A1 in Northumberland: Morpeth to Ellingham

Scheme Number: TR010059

7.34 Applicant's Responses to Deadline 9 Submissions

Applicant's Responses to Deadline 9 Submissions

Figure 2 - Alternative Route A

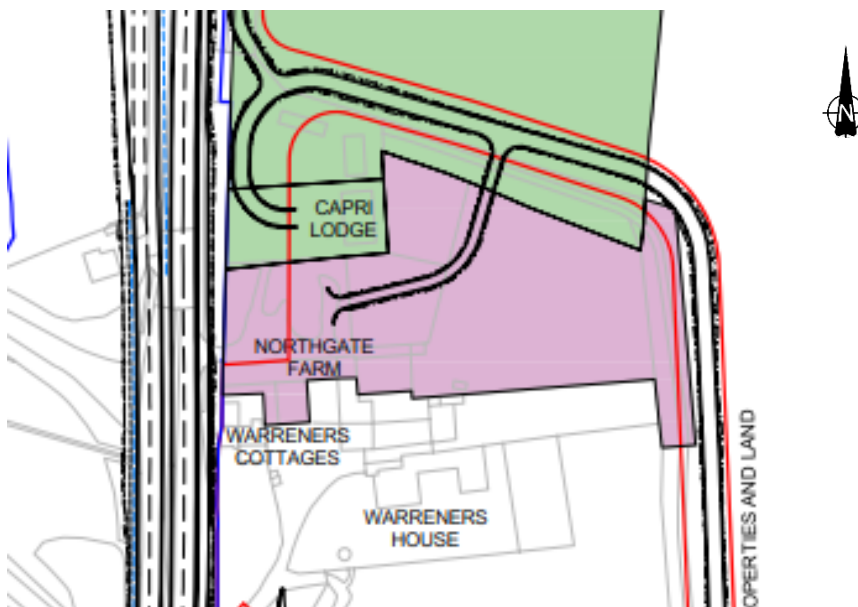
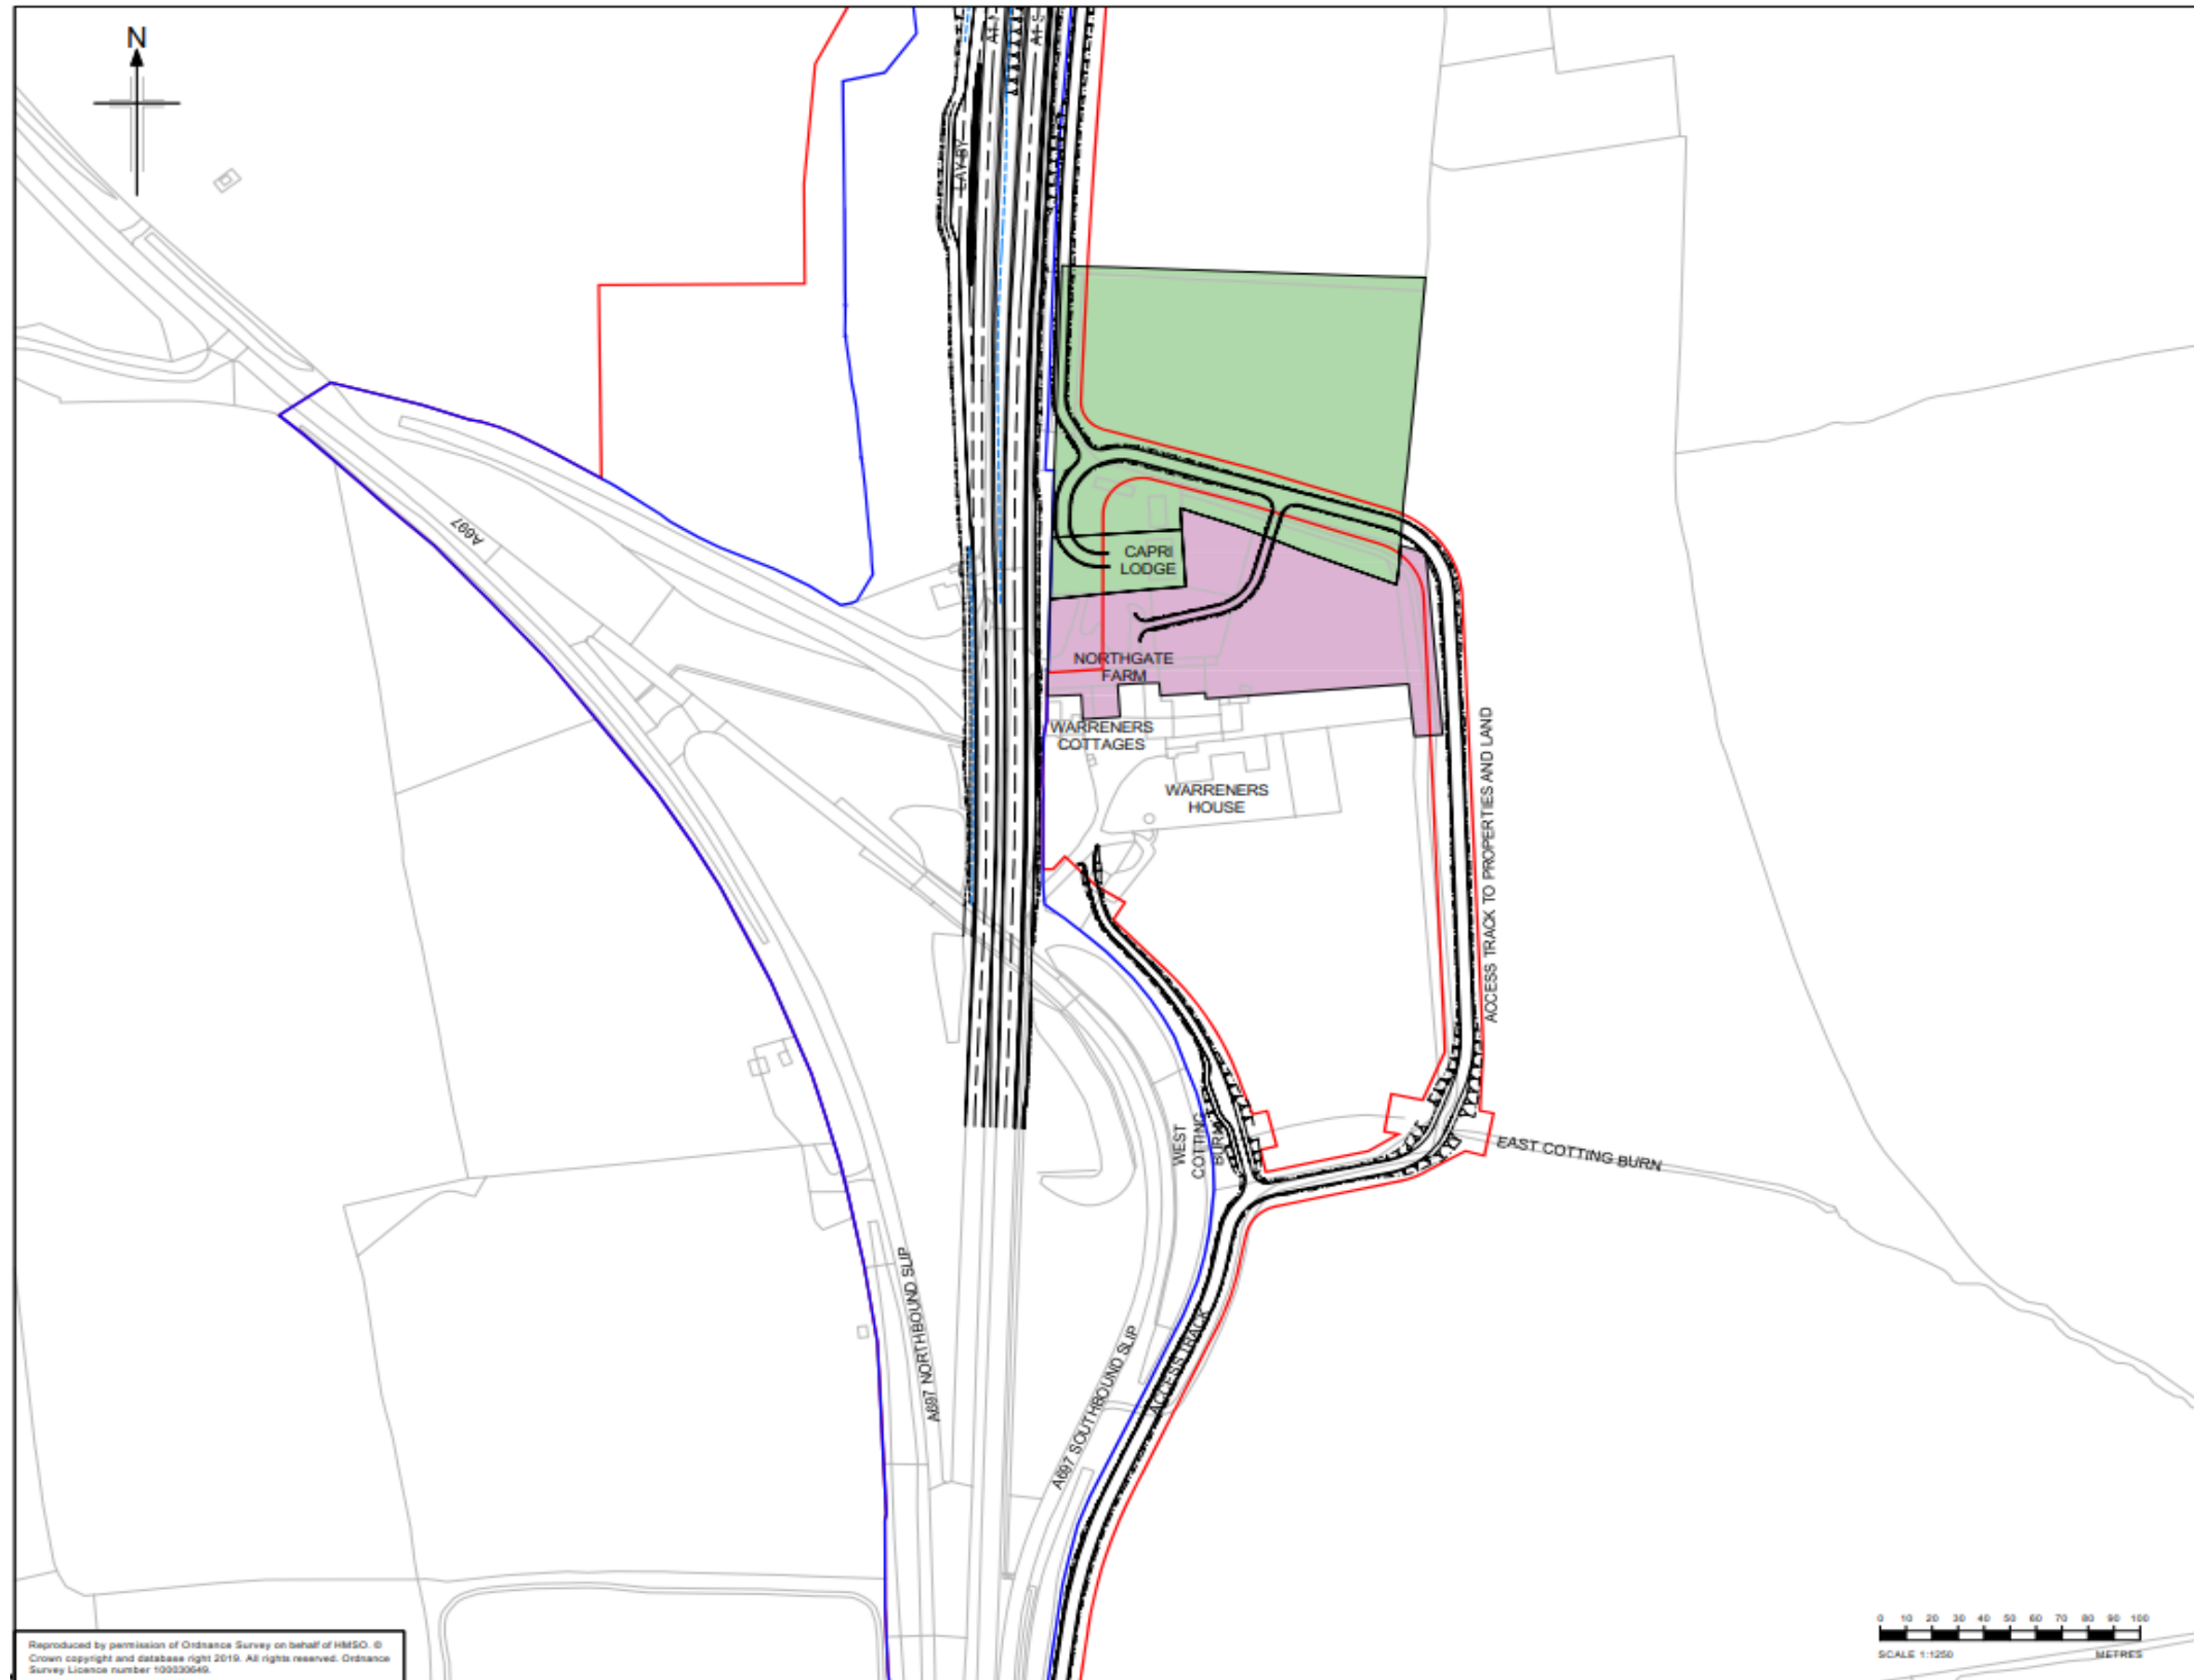
1	Take on the responsibility for constructing a 75-metre tarmac road which would partition the property.	<p>1. Alternative Route A would pass through both Mr Hawes's and Mr Davidson's land and could only be undertaken with the consent of all parties. If this proposal was adopted it would be because that was preferred by the parties.</p> <p>2. It is not accepted that the effect of the access when constructed within Northgate Farm would result in "partitioning", since the treatment of that access is not known and would be the responsibility of Mr Hawes to deliver. It would be open to Mr Hawes to select a surface treatment other than asphalt.</p> <p>3. As the final section of Alternative Route, A (from the PMA to Northgate Farm) would be constructed outside of the Order limits, it would require a separate planning permission. As confirmed on page 2 of REP8a-005, the Applicant would provide support to the affected landowners in obtaining planning permission for this element of the access, outside of the DCO process.</p>

2	With the road running through the centre of the garden we were making a compromise on visual effect and air quality.	<p>Visual Effects</p> <p>1. As noted above, the design of Alternative Route A, its surface treatment and landscaping cannot be known at this stage. These aspects would be matters for Mr Hawes to design rather than the Applicant.</p> <p>2. Alternative Route A would be visible from the north facing elevation of the dwelling, and the wider garden space to the east. In this regard, paragraph 3.2.10 of the Northgate Farm Private Means of Access Options Technical Note [REP8a-005] identifies that the access would be visible from the dwelling. It also identifies that the existing vegetation associated with the previously proposed access point would be retained, and as such the awareness of the Scheme to the north identified as occurring for R98, within Appendix 7.3 Residential Visual Effects Schedule [APP-218], and which Mr Hawes has previously expressed concerns about, would be substantially avoided, reducing the magnitude of impact on views from the dwelling to the north. The assessment of effects in [REP8a-005] has identified that, with Alternative Route A, the visual effects on the occupants of the dwelling, when considered from the primary outlook (the</p>

3	Accept the loss of additional trees at the front of the property.	<p>1. Paragraph 3.2.10 of the Northgate Farm Private Means of Access Options Technical Note [REP8a-005] identifies that the proposed access via Alternative A would impact directly upon the forecourt area due to a change in the point of access, requiring the removal of existing vegetation within the garden space. However, the existing vegetation associated with the previously proposed access point would be retained, and as such the awareness of the Scheme to the north identified as occurring for R98, within Appendix 7.3 Residential Visual Effects Schedule [APP-218], and which Mr Hawes has previously expressed concerns would be substantially avoided, reducing the magnitude of impact on views from the dwelling to the north. As set out at "Section 1.1.2, Item 2", above, there would not be a change in the overall magnitude of impact for visual effects, which would remain as reported within Chapter 7: Landscape and Visual Part A [APP-044]. The assessment of a slight adverse effect as concluded within Appendix 7.3 Residential Visual Effects Schedule [APP-218] remains appropriate.</p>

4	Take on additional responsibility for land works and landscaping. This included the repositioning of a well-established vegetable garden.	<p>1. The final section of Alternative Route A from the PMA to Northgate Farm is outside the Order limits and would need to be constructed under a separate planning permission by Mr Hawes as the landowner. This would include any ancillary works.</p> <p>2. As confirmed on page 2 of [REP8a-005], the Applicant would provide support to the affected landowners in obtaining planning permission for this element of the access, outside of the DCO process.</p>
	Although it is understood that this option is not favoured by Mr Davidson, as it involves some shared access, it is significantly better than the current proposal. Furthermore, it should be recognised that all three routes require a degree of shared use and maintenance.	<p>1. Regardless of the option selected, access rights for the use of the portion of the PMA within the Order limits for the residents of all properties at Warreners House will be secured through the DCO. There will be a standard provision for the landowner for each section of the proposed PMA access road to be liable for its maintenance. It is anticipated that a commuted sum for</p>
